DRB Application No.: **04DRB-01964 (P&F)**

Project # **1003854**

Project Name: **Waggoman-Denison Addition**

**RE: Lot 1, Block 26, Waggoman-Denison Addition / Minor-Prelim &
Final Plat Approval**

BLOCK 26, WAGGOMAN-DENISON ADDITION
 (FILED 5/24/1945 VOL. C, FOLIO 191)

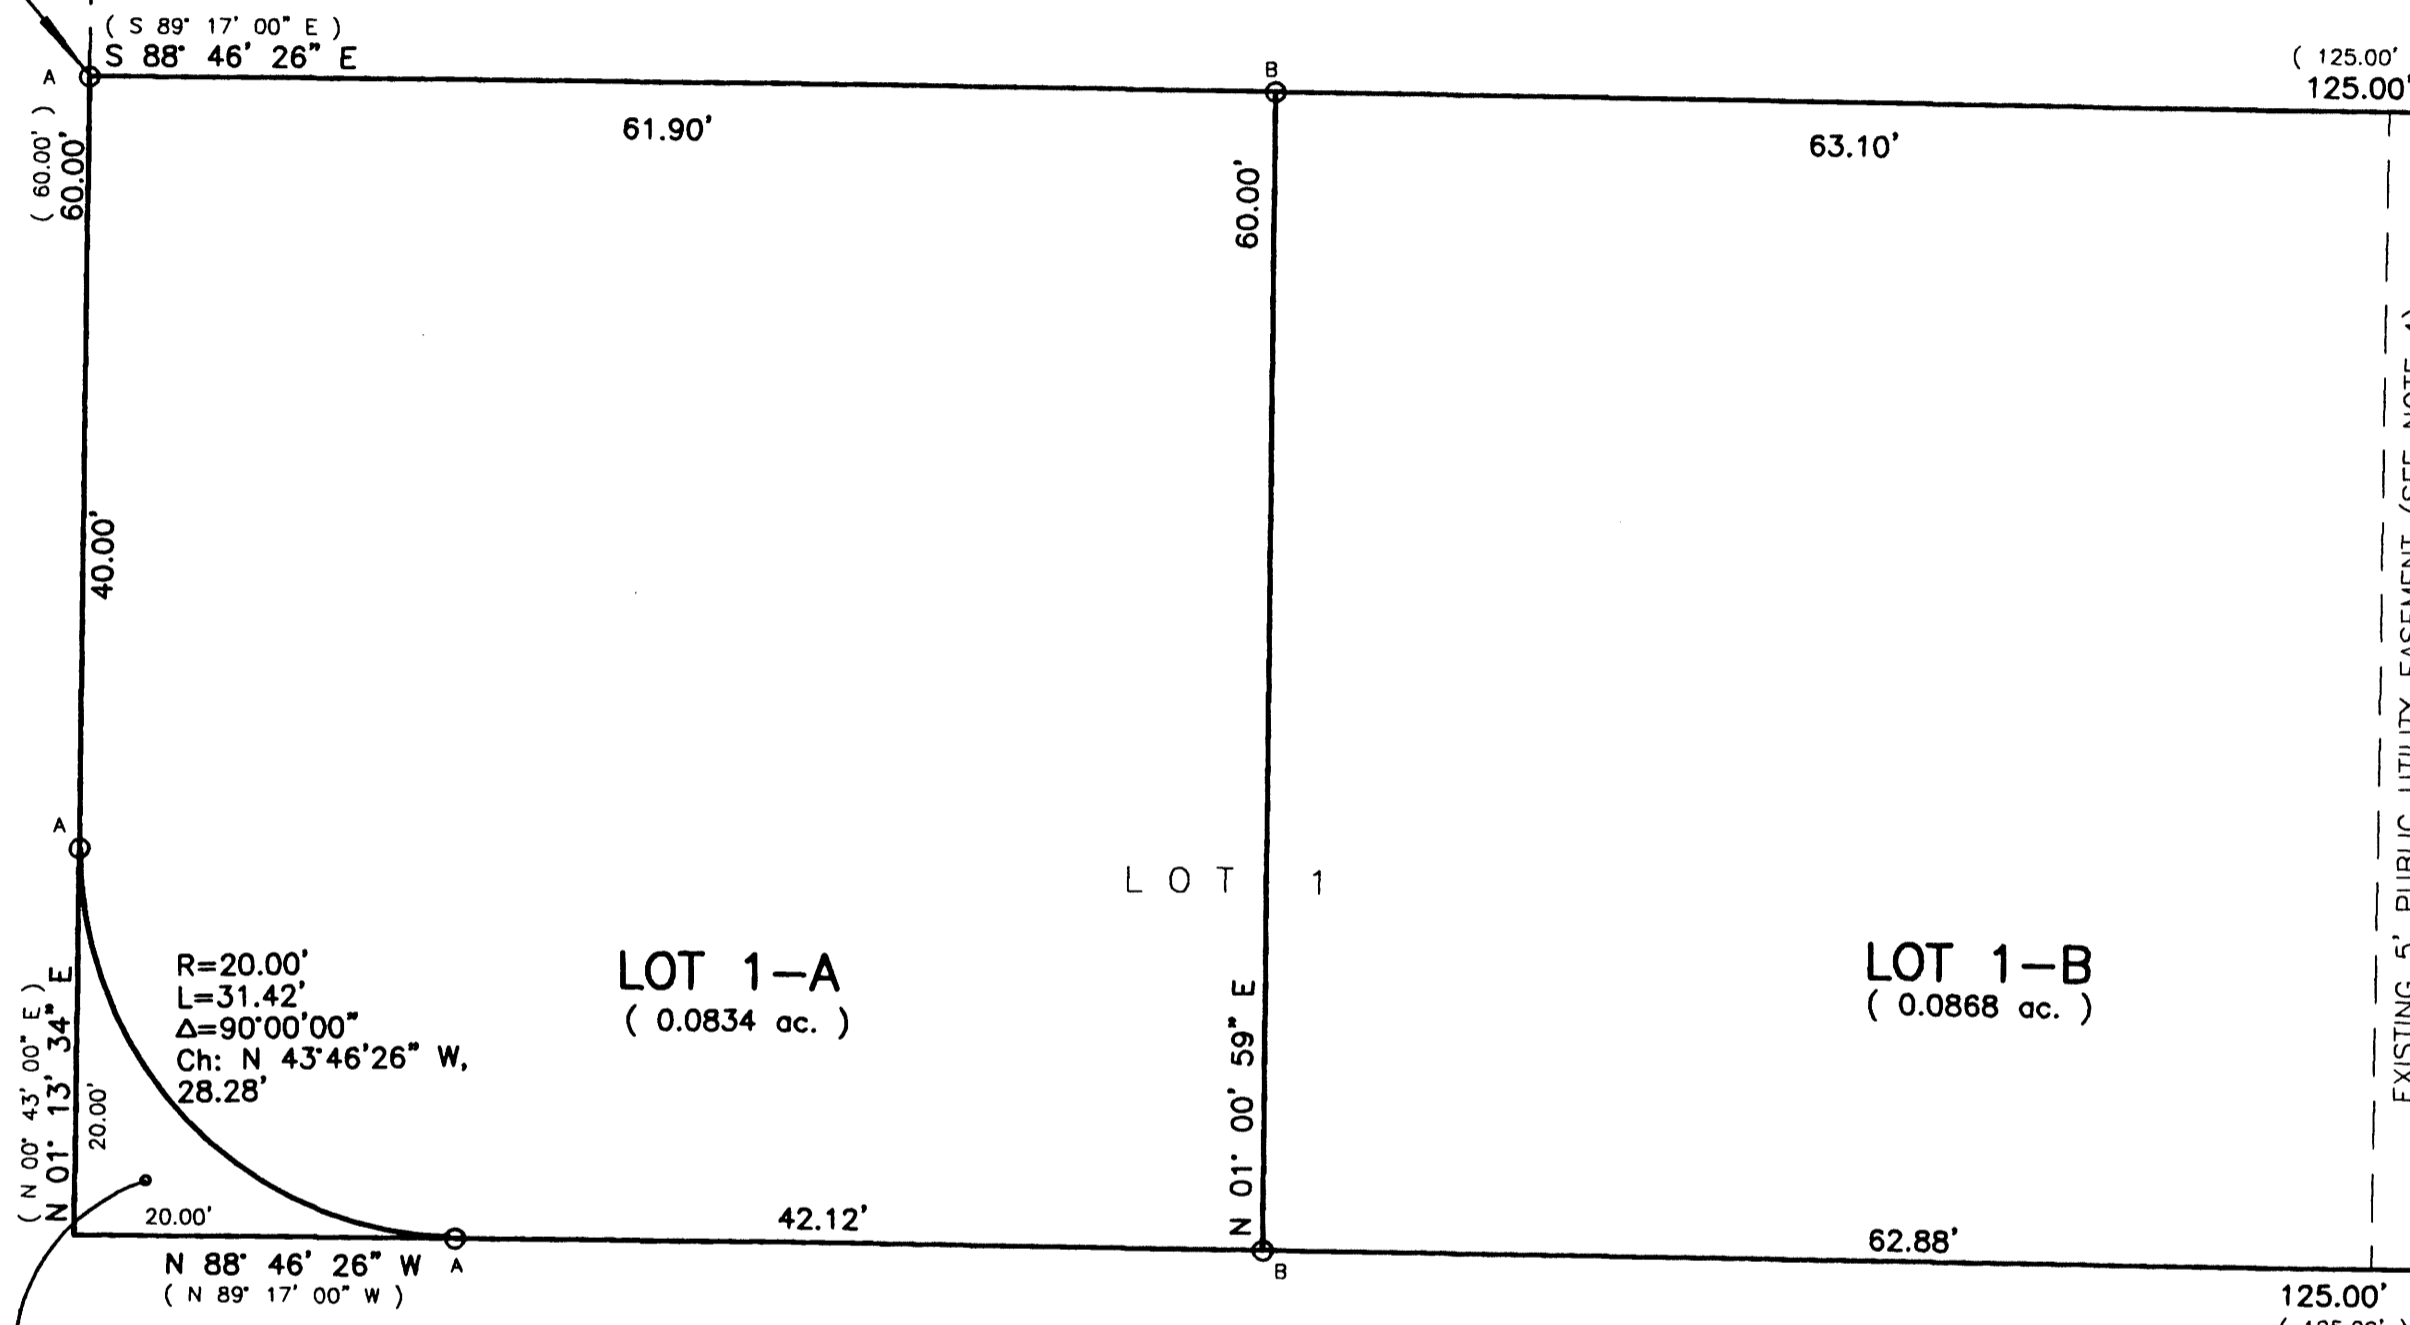
- 1.) Need to show private water/sewer easement across Lot 1-A on plat w/ maintenance + beneficiary language on plat.
- 2.) Need to establish separate accounts and pull water + sewer tapping permits before Ut Dev. will sign plat.
